## **Suffolk County Council (20041323)**

Comments on any other submissions received  
at Deadline 9

## **Bramford to Twinstead (EN020002)**

Deadline 10

TITLE: Figure 1  
 Proposed Archaeological Mitigation - Key Plan

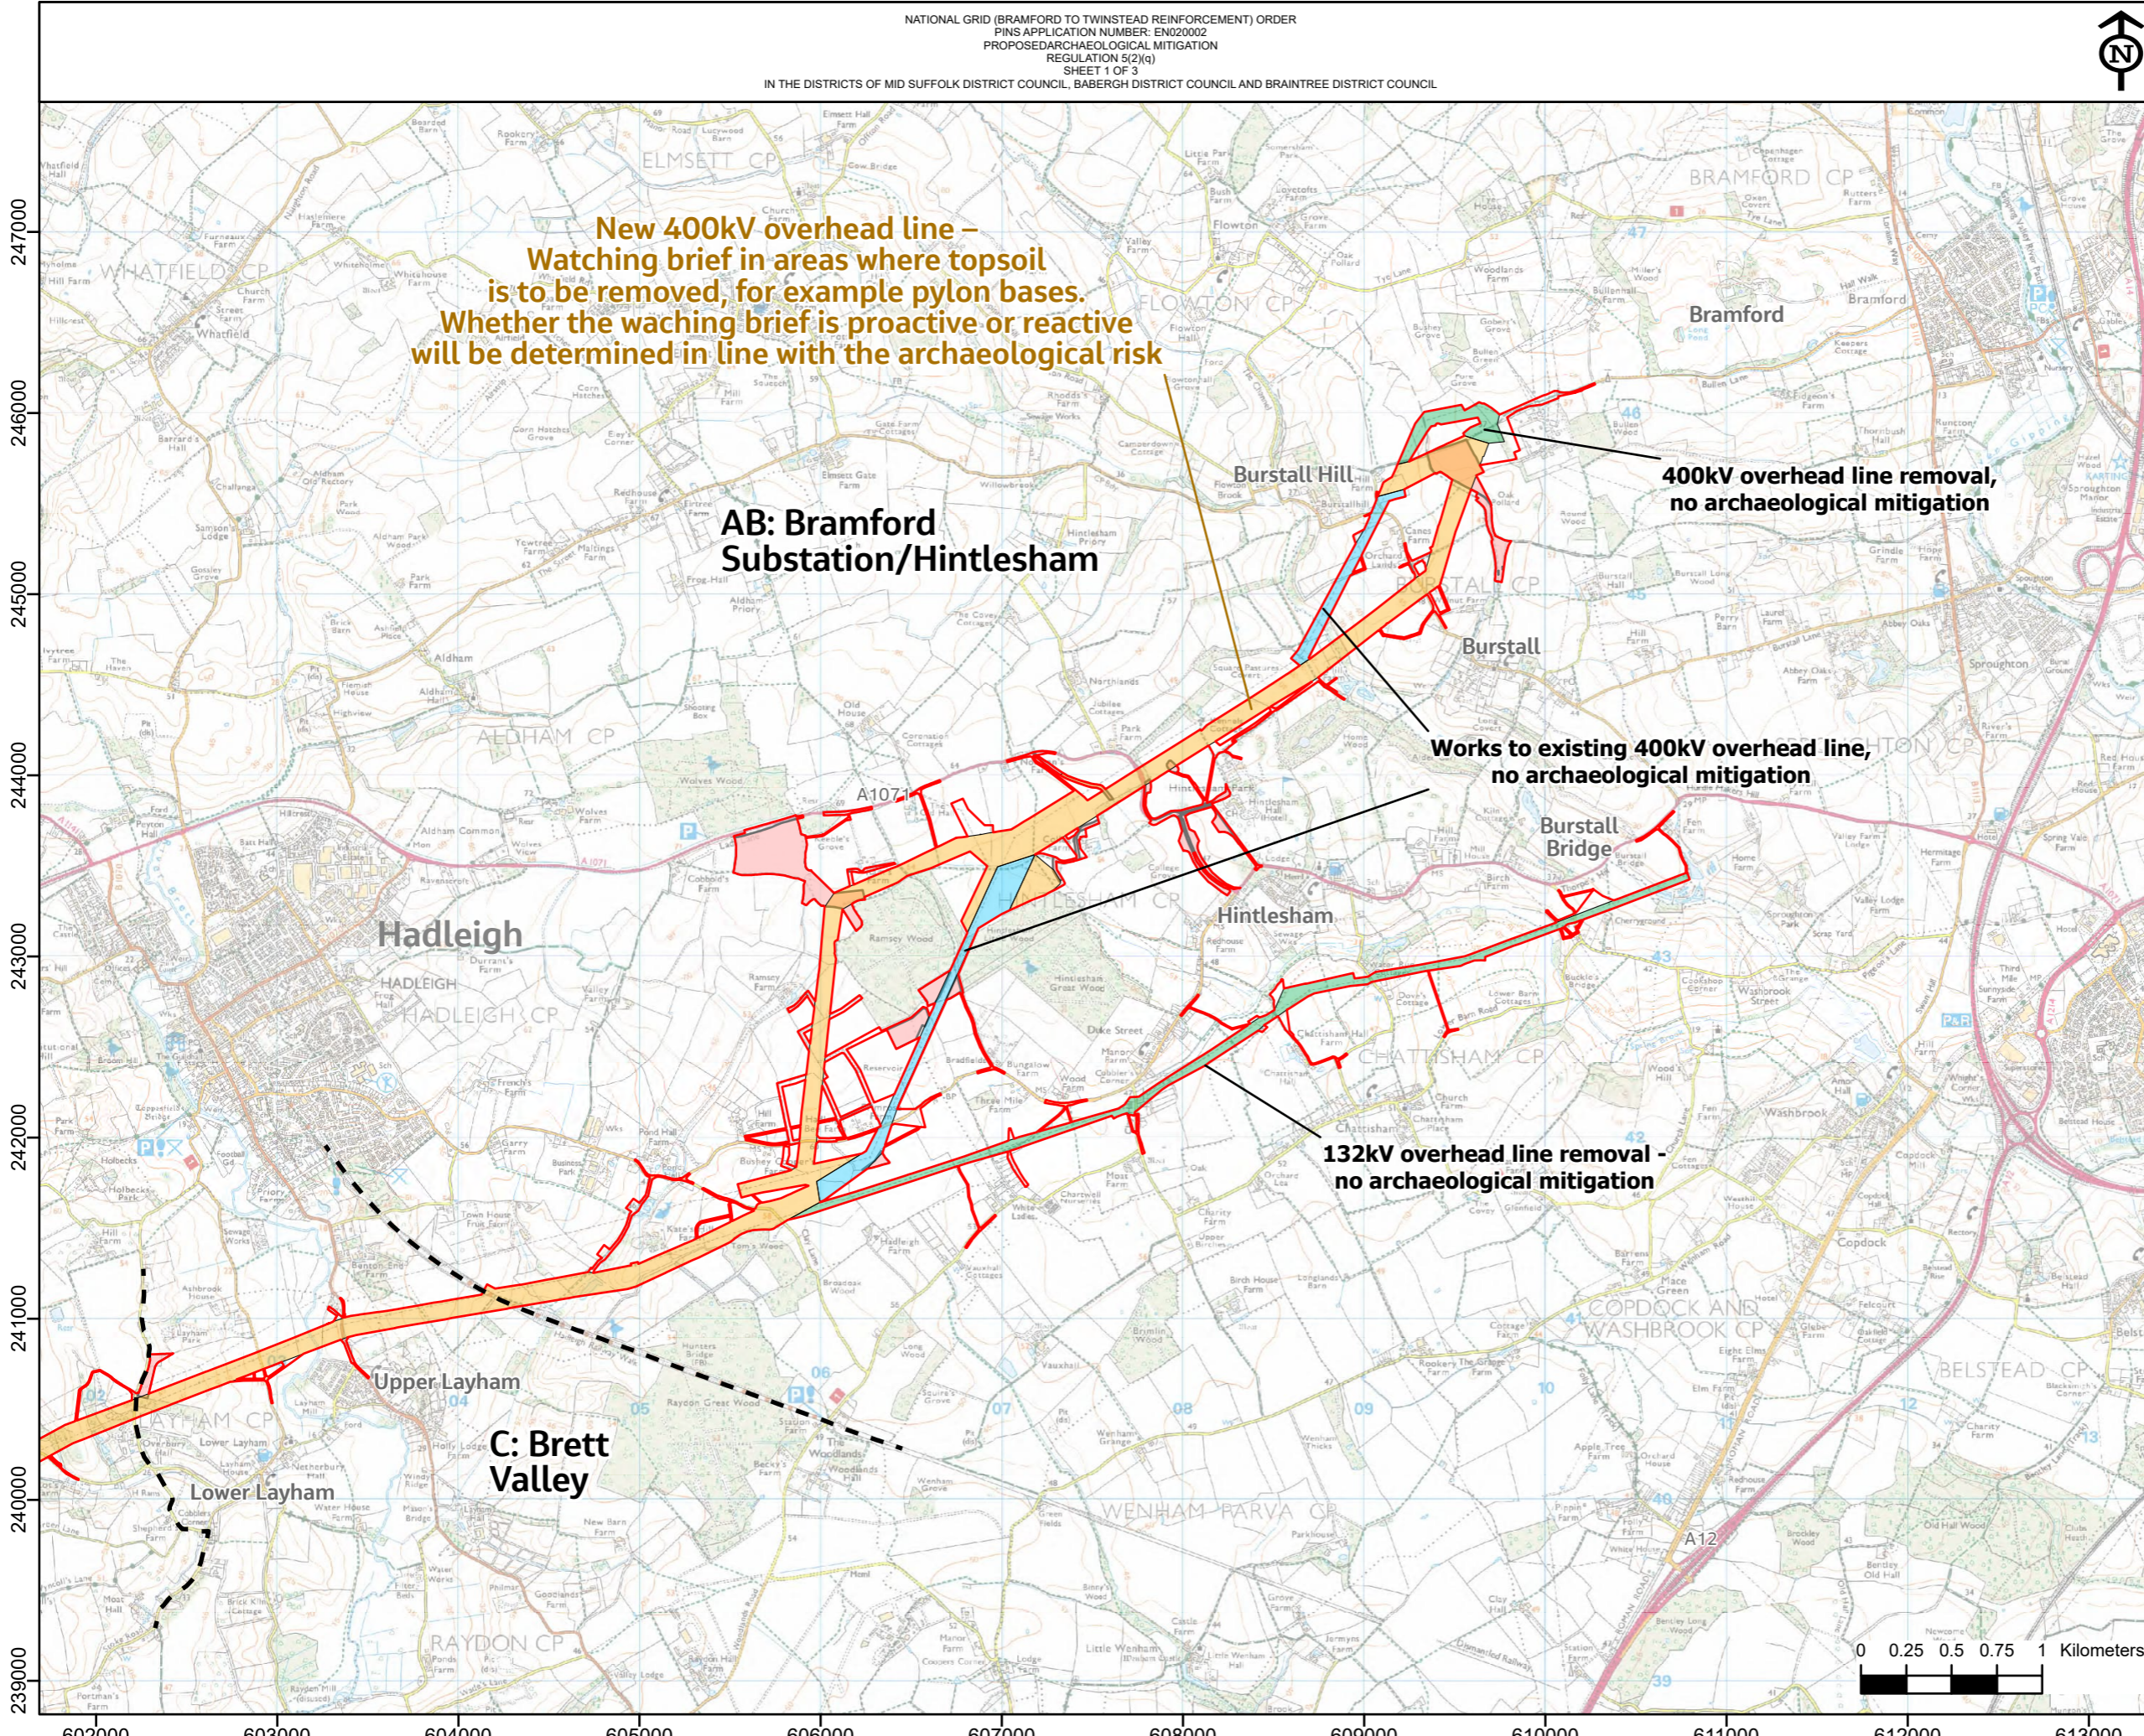
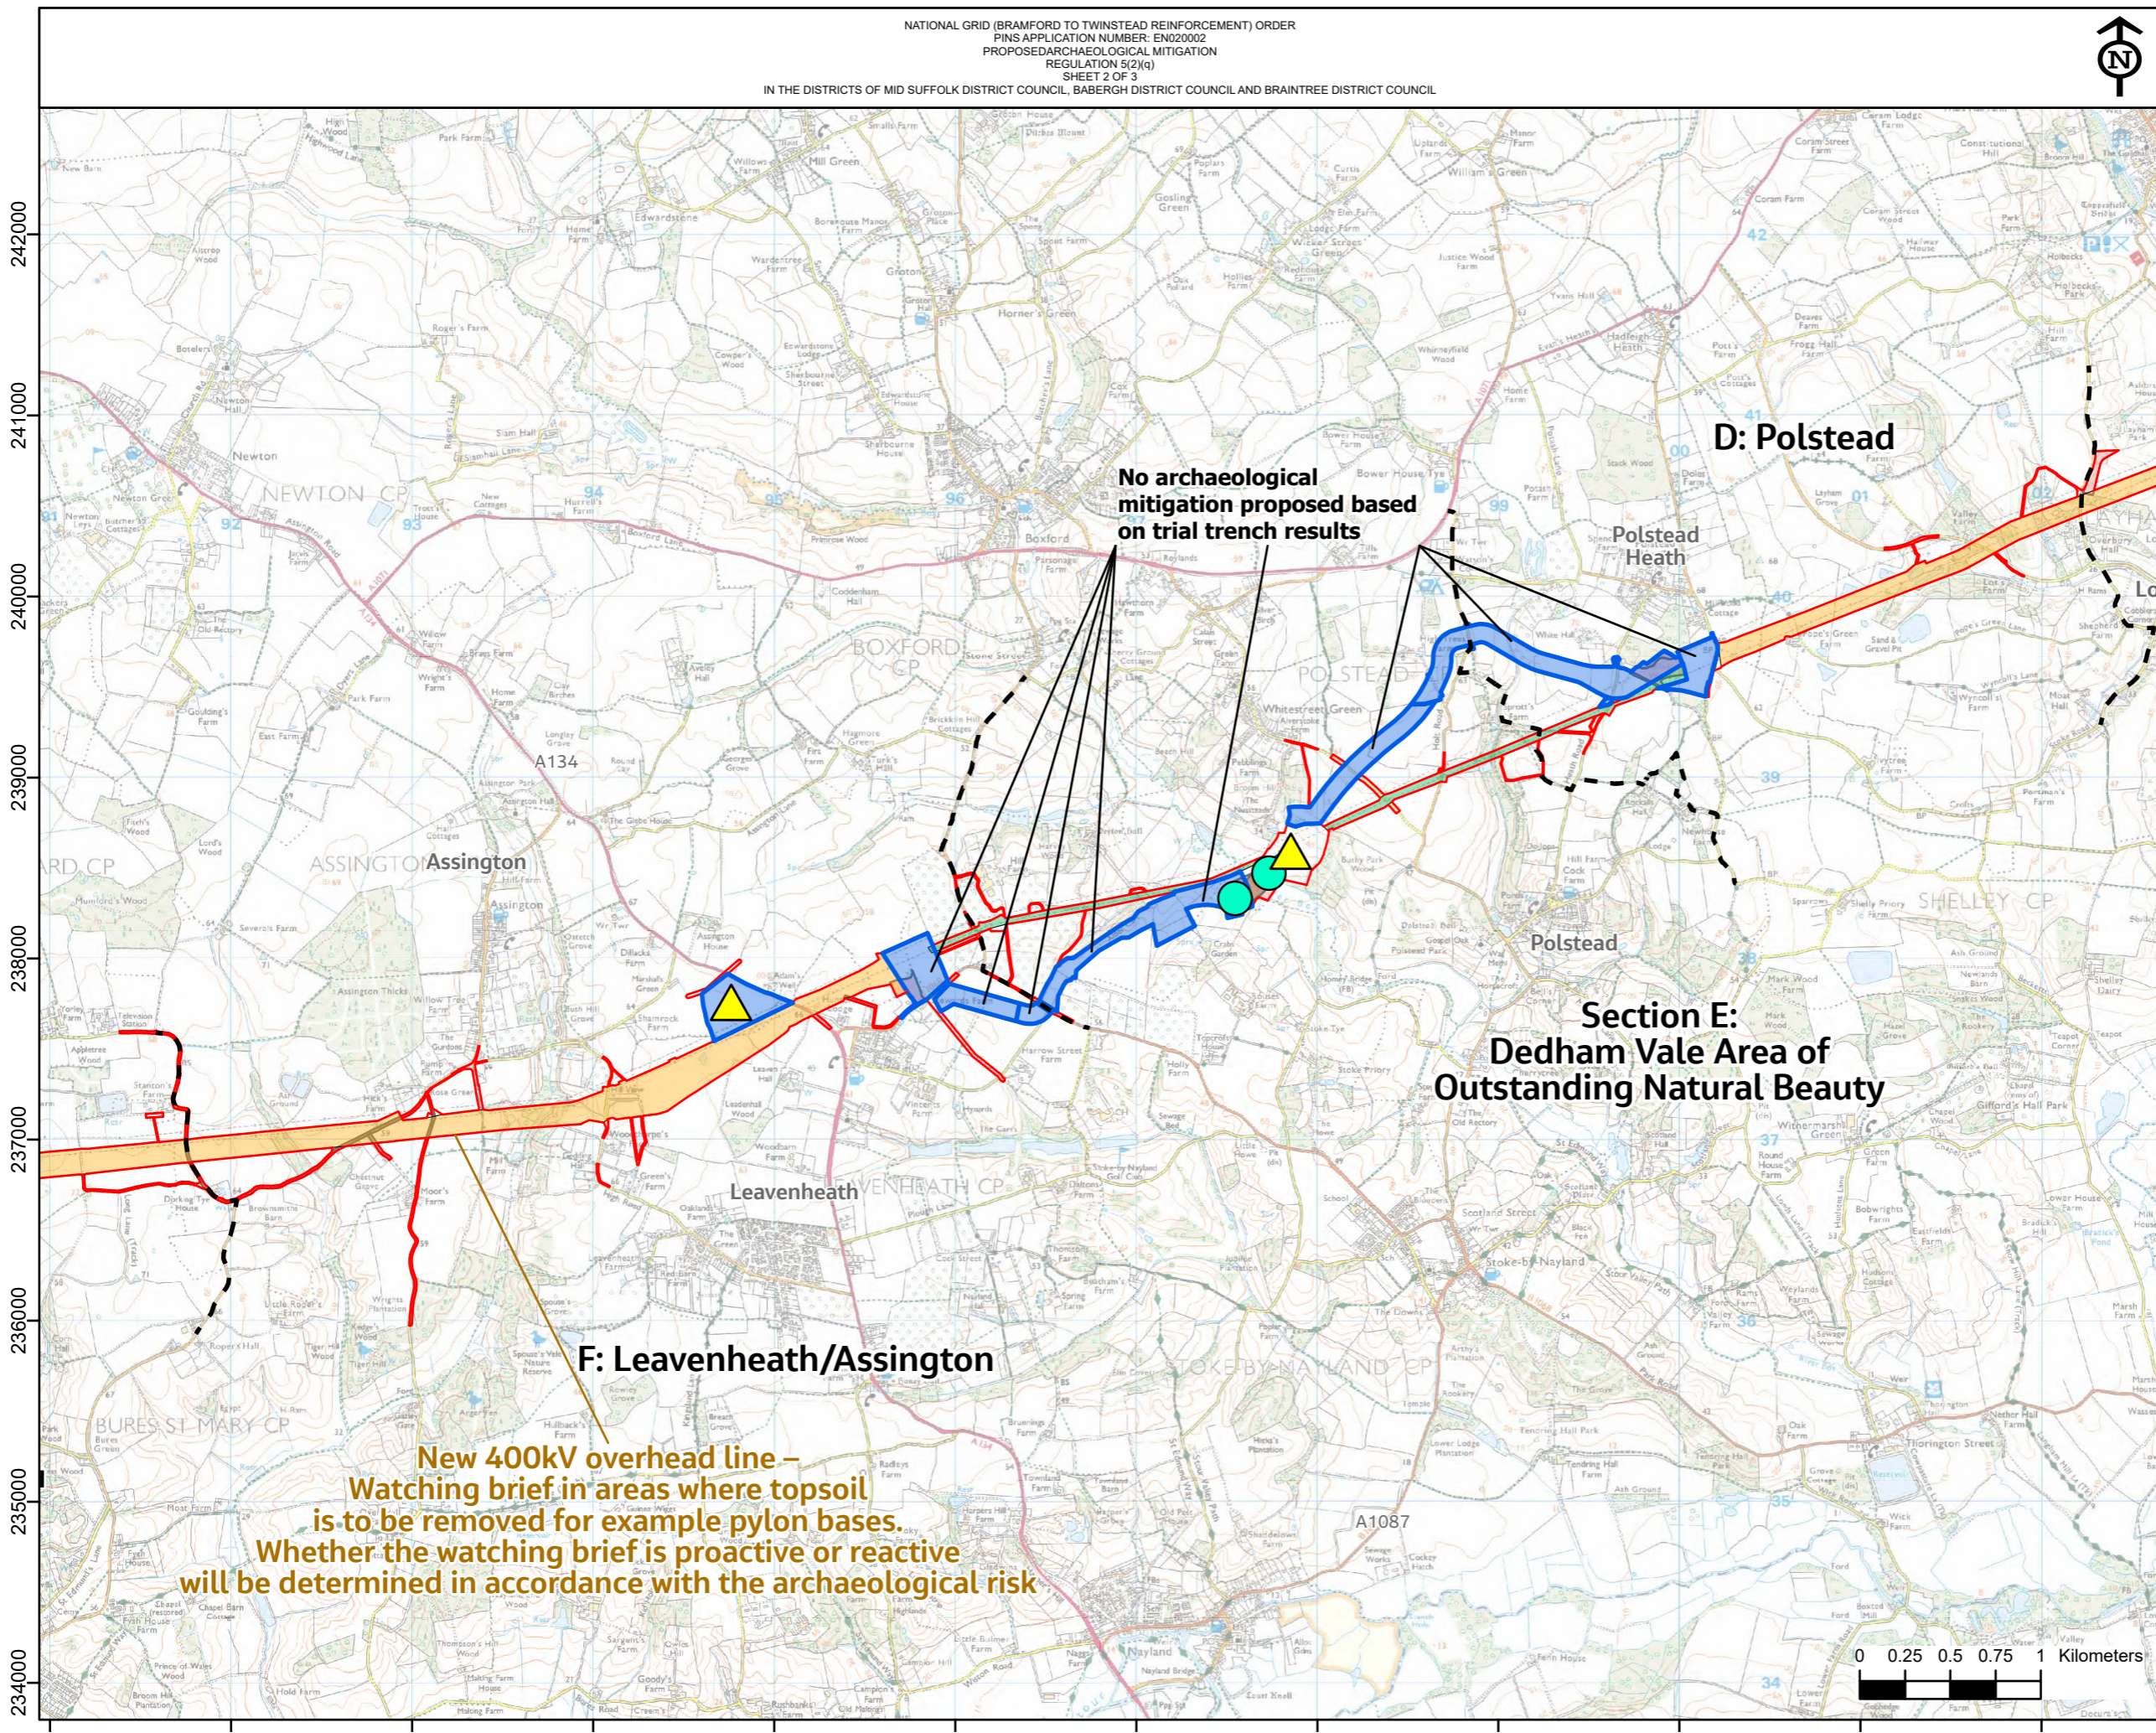
findings of each of the trenches.	
5c	Introduction - Aims and Objectives	1.3.3	<p>Archaeological mitigation is not proposed in the following areas (as shown on Figure 1: Proposed Archaeological Mitigation):</p> <ul style="list-style-type: none"> <li>• Locations where the 132kV or 400kV overhead lines are to be removed. The works in these areas will be limited to the pylon bases, which would have disturbed the soil during construction;</li> <li>• Modification works to the existing 132kV or 400kV overhead line. There will be works to the pylons and conductors of the existing overhead lines and in some areas adding arcing horns to the existing pylons. It is not anticipated that these works would require ground disturbance;</li> <li>• Area subject to a trenchless crossing. Although the drill pits are anticipated to be subject to archaeological mitigation, the line of the trenchless crossing would not be. This is because the trenchless crossings have been proposed in locations where the environment above the crossing is sensitive and the design has sought to avoid impacts to this</li> </ul>	<p>SCC (Archaeological Service) would note that in locations where overhead lines are to be removed there needs to be archaeological assessment to establish whether there will be impacts on any archaeology during the decommissioning and construction works.</p> <p>This would be for compounds, pylon construction areas and access routes constructed to facilitate the removal and modification works. If so, in areas of ground disturbance appropriate levels of archaeological evaluation will be required to determine the impact of the proposal on archaeology.</p> <p>For modification works, construction compound/storage area locations would need to be assessed and mitigated appropriately.</p> <p>The area of the trenchless crossing is to be subject to geoarchaeological and palaeoenvironmental archaeological assessment, providing deposit models and palaeoenvironmental information, to determine the level of mitigation (if required) on sensitive deposits of archaeological importance that would be damaged or destroyed by the proposed trenchless crossing. Therefore, there is archaeological mitigation proposed for the trenchless river crossing areas, and this section should be removed from 1.3.3.</p>
